# SADDLEHORN RANCH FILING NO. 1

## A PARCEL OF LAND LOCATED IN THE SOUTH HALF OF SECTION 3 AND THE NORTH HALF OF THE NORTH HALF OF SECTION 10, TOWNSHIP 13 SOUTH, RANGE 64 WEST OF THE 6TH PRINCIPAL MERIDIAN EL PASO COUNTY, STATE OF COLORADO

SADDLEHORN RANCH FILING NO. 1  
JOB NO. 25142.01  
JANUARY 10, 2020  
SHEET 3 OF 5

SADDLEHORN RANCH FILING NO. 1
JOB NO. 25142.01
MAY 20, 2020
SHEET 3 OF 5

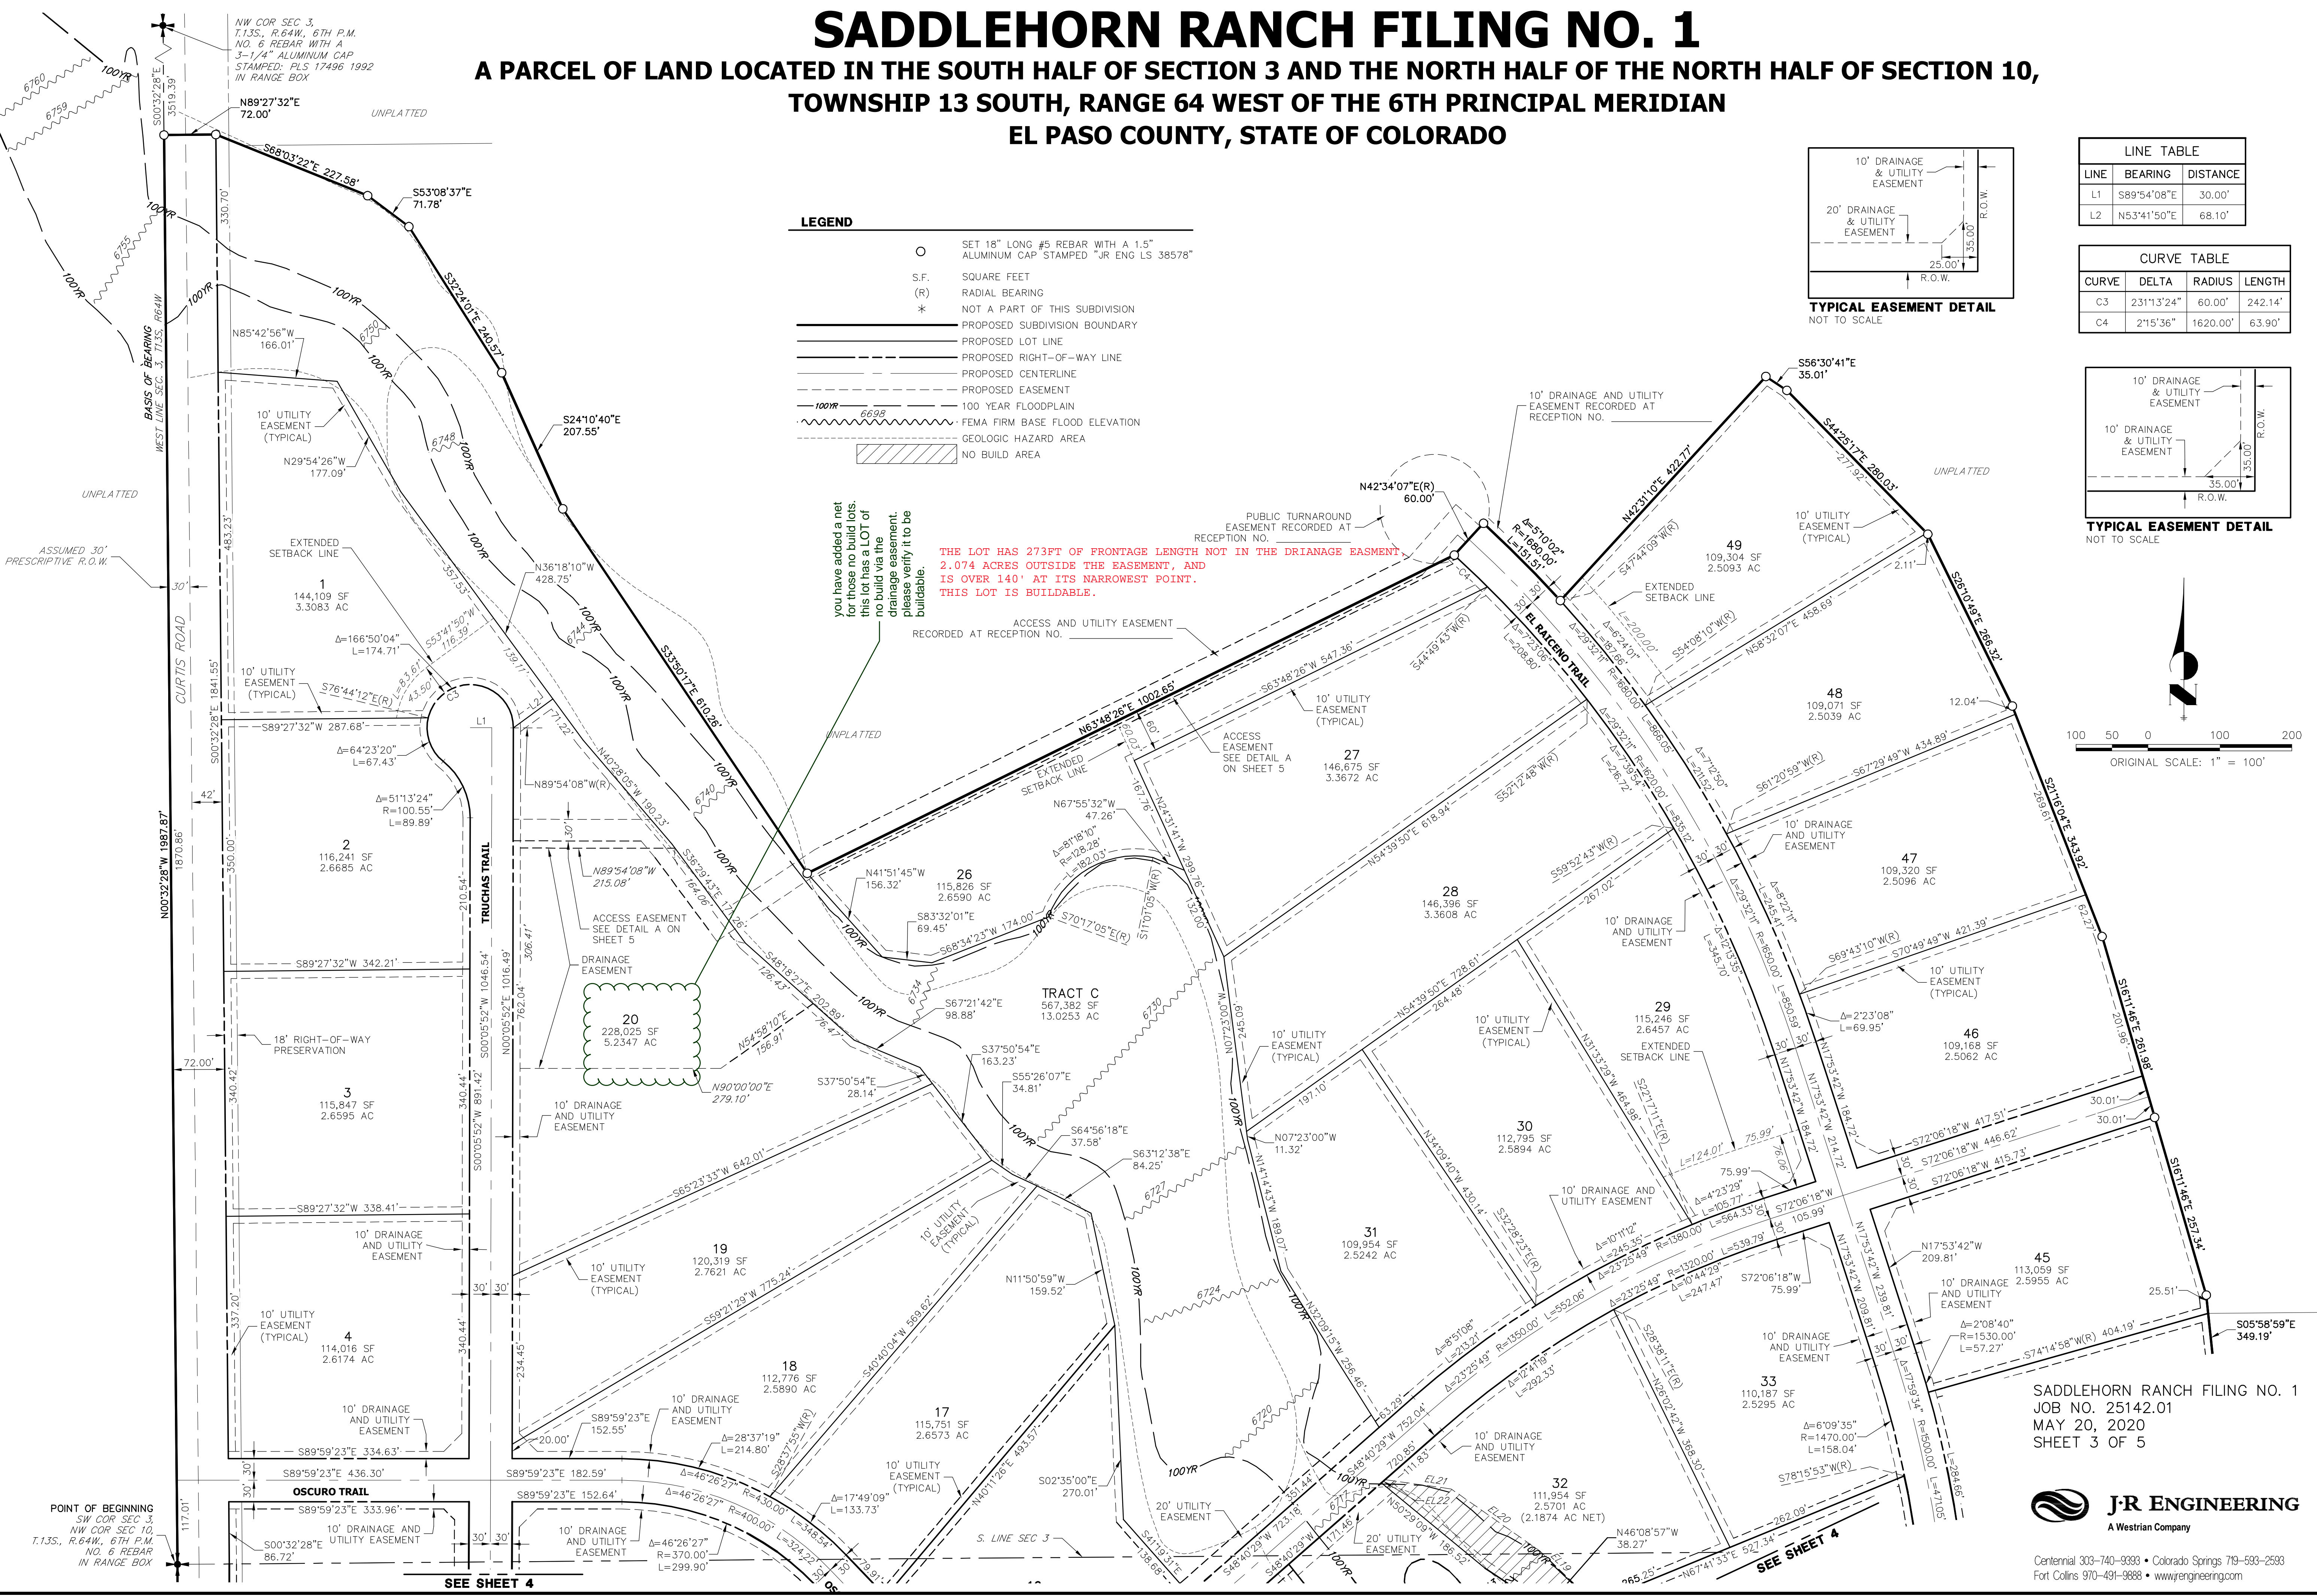
This would be a great location for a reference map that shows where to find the plat details

This is only a temporary condition and has not been brought up in earlier reviews. Will we need to request a deviation. We already got one for temporary cul de sac length.

2 points of access are required for subdivisions in excess of 25 lots.

Will add a key map

A PARCEL OF LAND LOCATED IN THE SOUTH HALF OF SECTION 3 AND THE NORTH HALF OF THE NORTH HALF OF SECTION 10,
TOWNSHIP 13 SOUTH, RANGE 64 WEST OF THE 6TH PRINCIPAL MERIDIAN
EL PASO COUNTY, STATE OF COLORADO

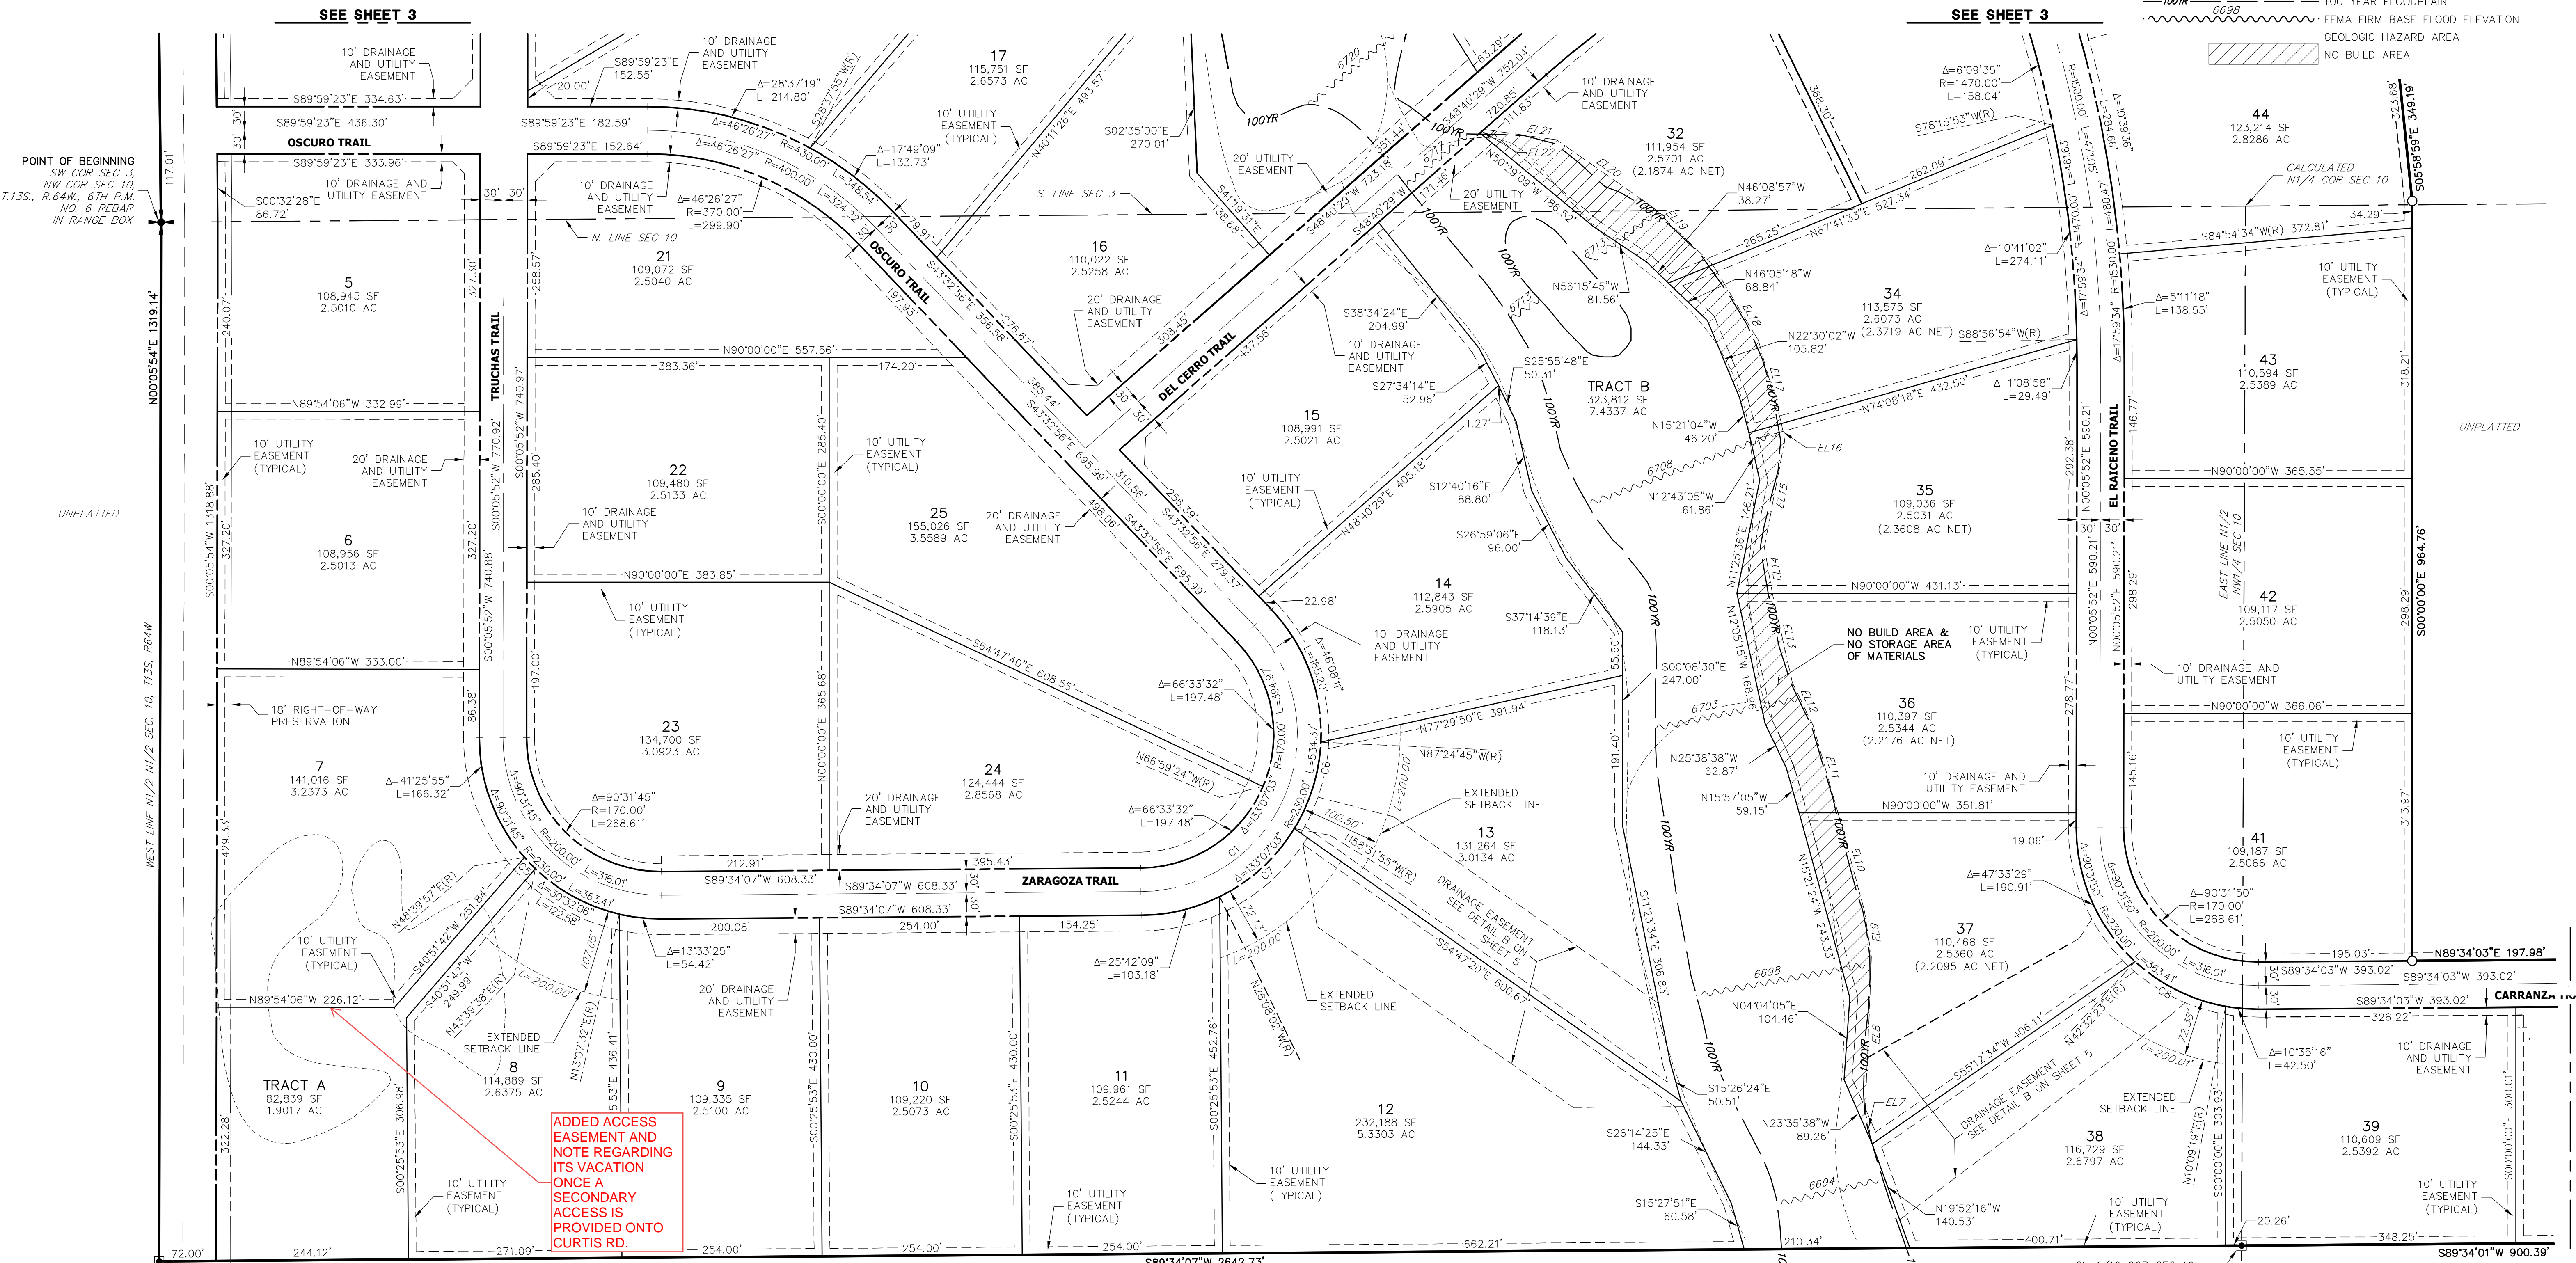
Several lots - cul de sac, flag and this one have extended setback lines shown on the prelim plan. Do you want us to show a setback line on the plat when it is non standard.

does this lot meet the minimum width at the front setback?

how can they gain access?

Please add net acreage for those lots with no build

Will this be acceptable (2.35 buildable)
